Your Ref: OWPC21023
Our Ref: BE/102/18/PL 06-09-2018
Please ask for:
Mr S Davis

Erection of 1 no. dwelling
312 Chichester Road Bersted

Thank you for your internet representation made on 7th January 2019 which has been recorded as '**an objection**' with the comments as follows:

| PROJECT TITLE                                                  |  | DRAWING TITLE                  |                         | No | REVISION | DATE |
|----------------------------------------------------------------|--|--------------------------------|-------------------------|----|----------|------|
|                                                                |  | DRAWN BY<br>AP                 | DRAWING No<br>PA-276-05 |    |          |      |

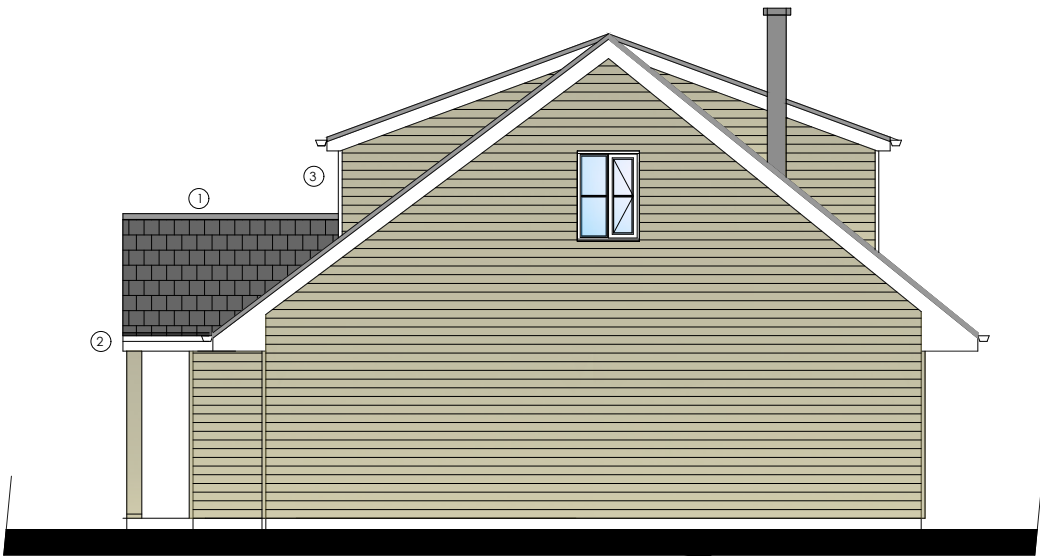
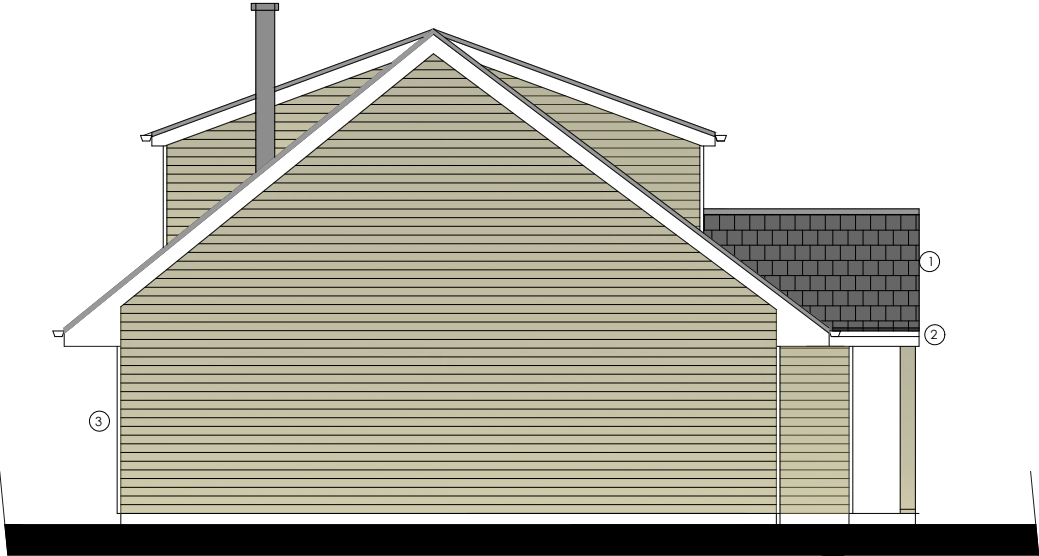
- 4. There are 4 windows and 1 door to be installed to the front of the house which will directly overlook our property and result in a loss of privacy. Additionally, due to the two-storey nature of the house, our views would be significantly affected.*

- 8. In line with the Bersted Neighbourhood Development Plan, the design of new development does not contribute to the appearance or local character of Bersted and does*

not connect visually or integrate with the surrounding area. Although it will not be very visible from the main road, I trust full consideration will be given to these points, regardless.

PROJECT TITLE Proposed Development at 312 Chichester Road Bognor Regis	DRAWING TITLE Proposed Site & Location Plans		No	REVISION	DATE
	STATUS Planning Application				
	SCALE As Shown	DATE 20.03.2018			
	DRAWN BY AP	DRAWING No PA-276-02

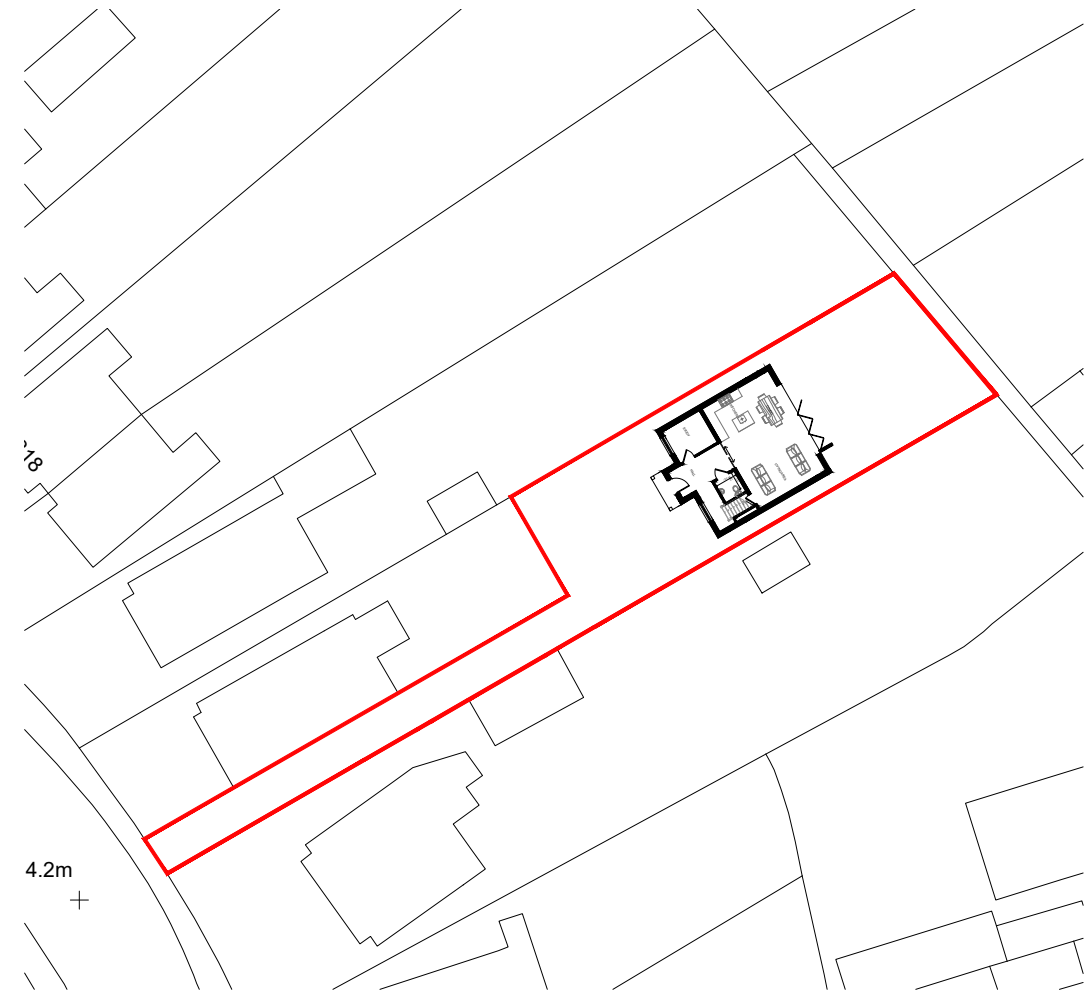
- 2. The proposed rear parking area backs straight onto our rear garden and this would adversely affect the enjoyment of our garden by way of noise and disturbance associated with the operation of vehicles.*

- 7. The proposed, narrow access road opens straight onto the busy A259 next to a telegraph pole, giving it very poor visibility and a very sharp angle of access. Cars are often already parked in front of our property and neighbouring properties, making access and visibility to this road even more difficult.*
